KITTITAS COUNTY COMMUNITY DEVELOPMENT SERVICES

July 27, 2009

RE: Markus & Repp Short Plat (SP-09-00009)

The Kittitas County Community Development Services Department has determined that the Markus & Repp Short Plat (SP-09-00009) is a complete application and hereby grants *conditional preliminary approval* subject to the following conditions:

MARKUS-REPP SHORT PLAT
PART OF SECTIONS 29 & 30, T. 17 N., R. 19 E., W.M.

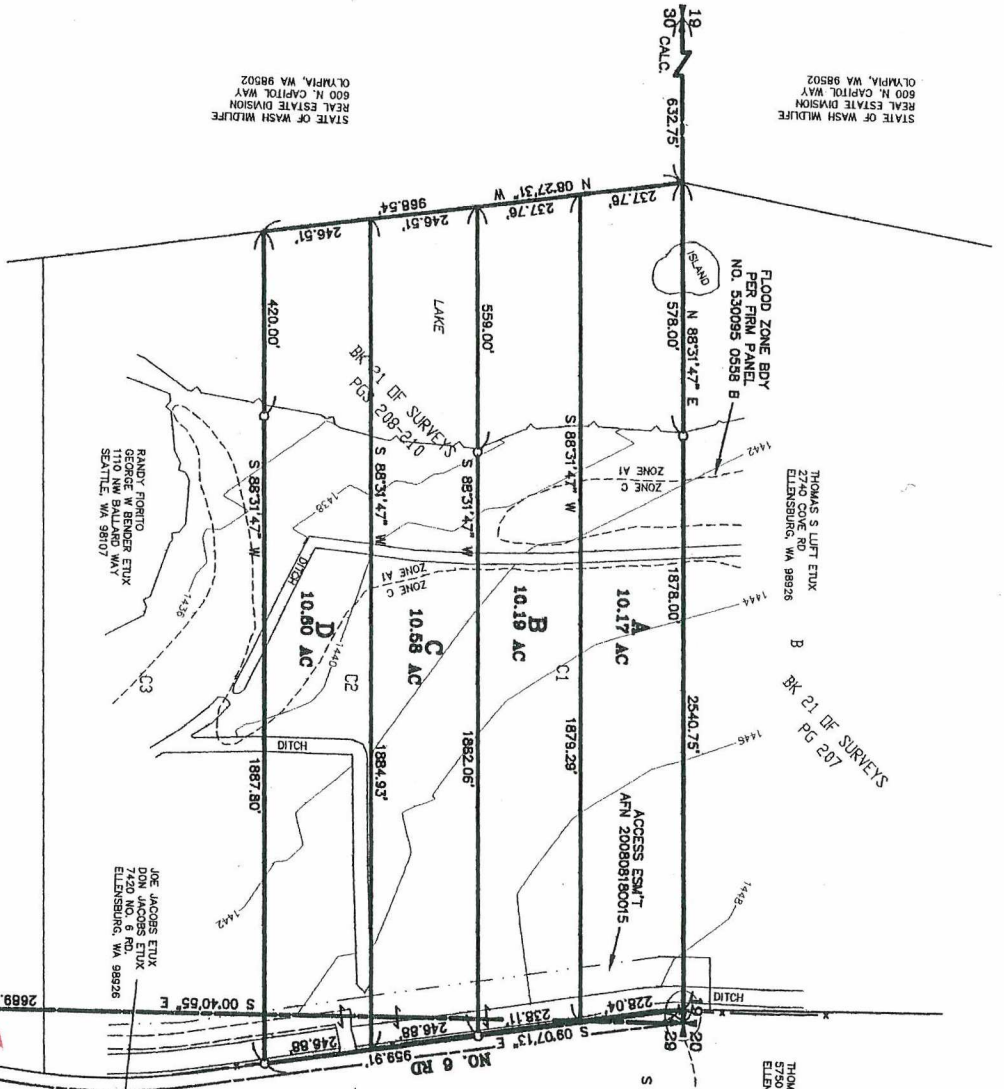
1. Both sheets of the final mylars shall reflect short plat number SP-09-00009 and an accurate legal description shall be shown on the face of the final plat.

8. Individual wells are required to have a 50 foot setback from neighboring property lines (KCC 17A.08.025). Please see the comments from Kittitas County Public Health Department for further information and requirements.

11. The addresses shall be clearly visible from both directions at the County Road for all properties.
12. The Fire Department access road shall be capable of supporting 75,000 lbs in all weather, be 20' wide, provide 13'6" vertical clearance and provide for adequate turn-around for fire department apparatus.
